Arun District Council (ADC)
Arun Civic Centre
Maltravers Road
Littlehampton
BN17 5LF

Application WA/60/26/PL - Land south of the Black Horse Pub Binsted BN18 0LP -

Siting of 6no. glamping pods with asse' structures, access, car parking and landscaping (retrospective) Application may affect the setting of a Listed Building.

2bed 5 person
Shepherd's Hut

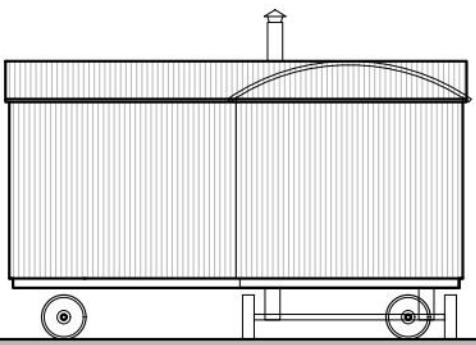
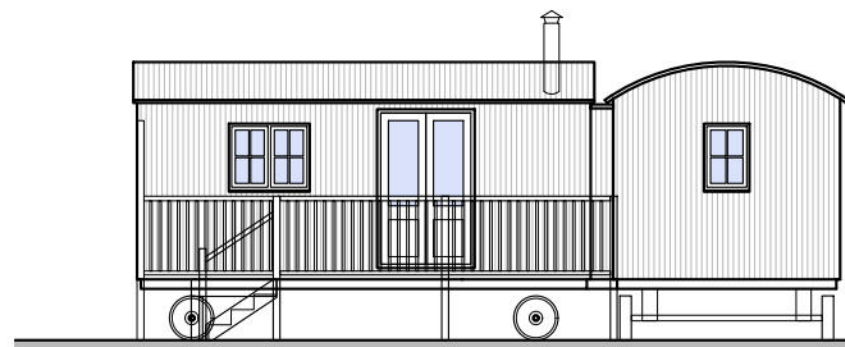
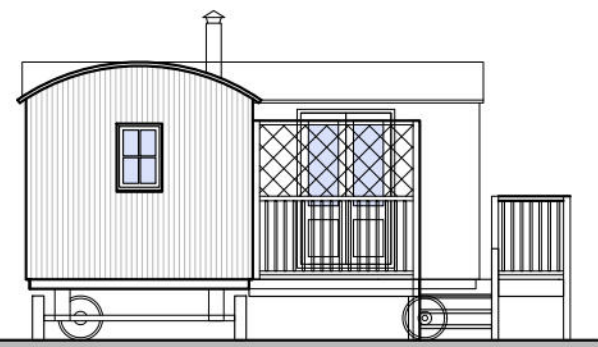
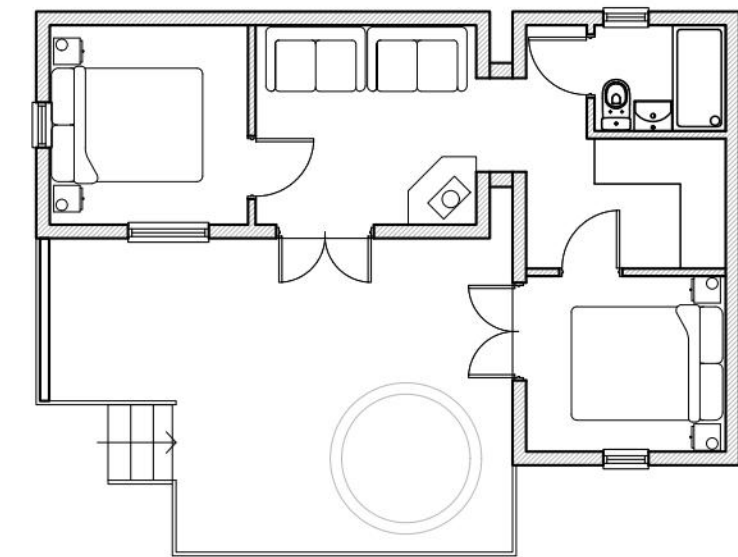
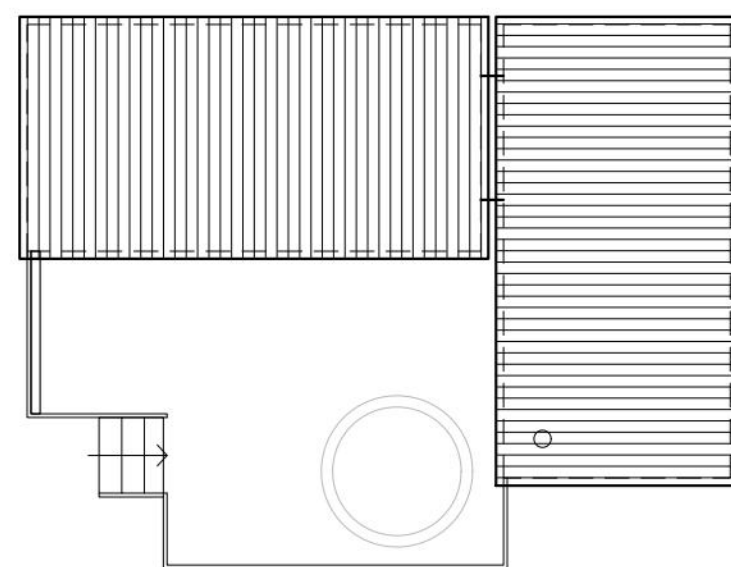
Reference the application, each individual 'pod' now has a far greater 'bulk' becoming overbearing in scale i.e. timber-clad 'top to toe' rather than off-ground on decorative wheels in a 'shepherds-hut-style', various outbuildings surround each hut being of both prominent sauna and hot tubs + log stores serving some three 'steel chimneys' per unit; each 'pod' too is surrounded by high interlocking fence panels.

All 'pods' appear of the same increased-scale of two bedrooms yet housing "five persons", is it assumed the "snug" may become sleeping arrangements for the additional person.

CLIENT	BINSTEAD FARMS LTD				
ARCHITECT	SIMON HARVEY DESIGNS LTD				
JOB TITLE	NESTLED, LAND ADJ BINSTEAD LANE BINSTEAD, ARUNDEL				
DRAWING TITLE	DRAINAGE DESIGN				
DRAWN	LH	ENGINEER	C SLADE	CHECKED	CS
DATE	JAN 2026		SCALE @ A1	1:200	
JOB No.	C3944	STATUS	DRAWING No.	101	REV.
		PL			3

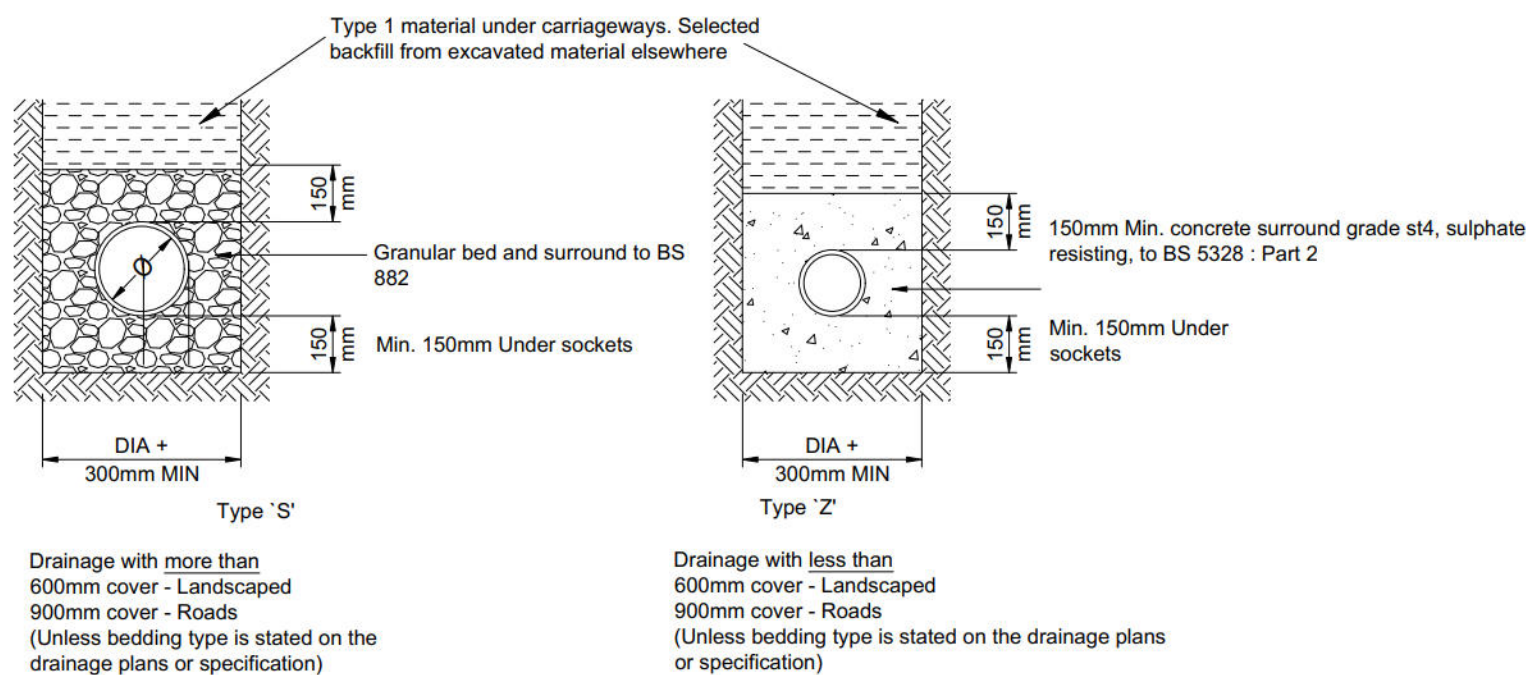
Further, there appears a possible issue regarding disposal of hot-tub water, it is understood the developer believes there is "no credible pathway" to Binsted Rife but, as part of the planning process will ADC not require confirmation by specific independent survey/s and monitoring along with perhaps over-winter rainwater monitoring too given a potentially high-level of groundwater in the vicinity.
